Engineers Comments Regarding Condition 4

APPLICATION **FG/36/19/DOC**
NO:

Registered: 25-MAR-19
Site Address: Quercus Nursery Littlehampton Road Ferring BN12 6PH

Description of Works: Approval of details reserved by condition imposed under ref FG/52/18/PL relating to Condition No 4 surface water drainage.

Figure 1

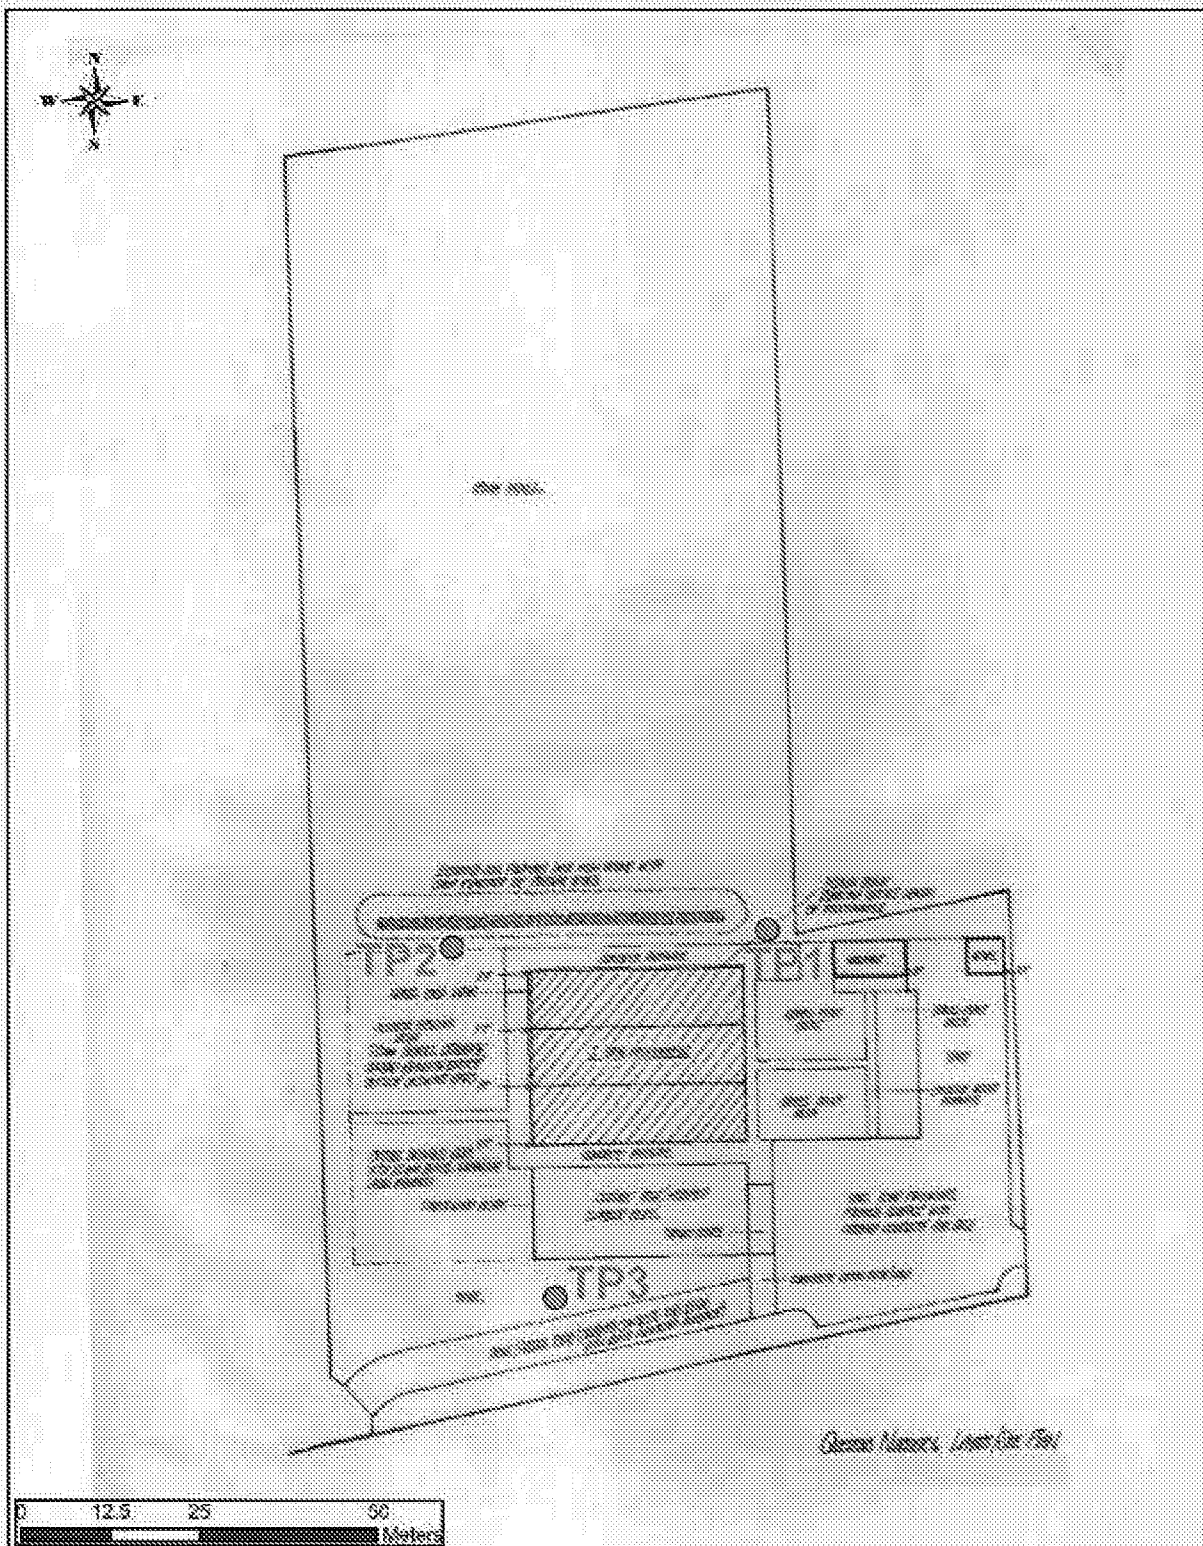
2. Infiltration testing is inadequate with only one test being completed at each pit location. As highlighted by the condition testing must be conducted in the winter and in accordance with BRE365. BRE365 requires three repeat tests to be completed at each location. The worst result from these results should be used in design.

Figure 3

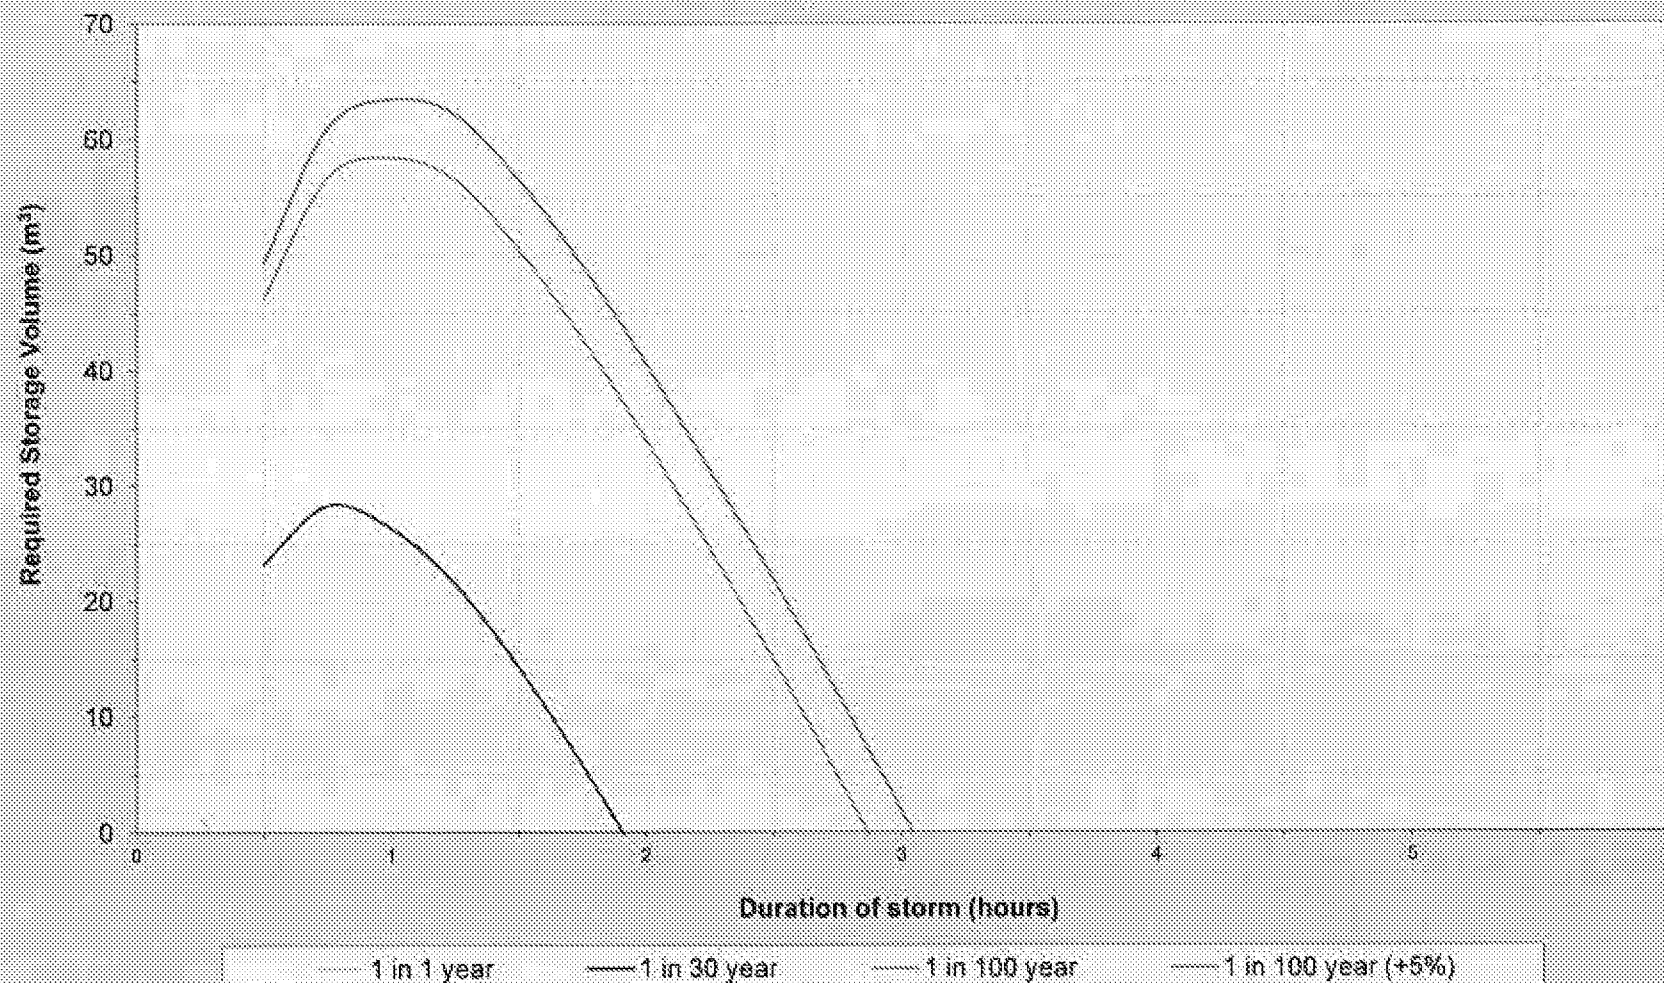
1. A 40% allowance for climate change must be applied. The 20% allowance used does not meet current policy requirements. This was highlighted in my original comments to FG/52/18/PL.

5. No calculations have been provided which demonstrate the adequacy of design.
6. Drainage layouts need to be updated to ensure they meet the requirements set out in our checklist.
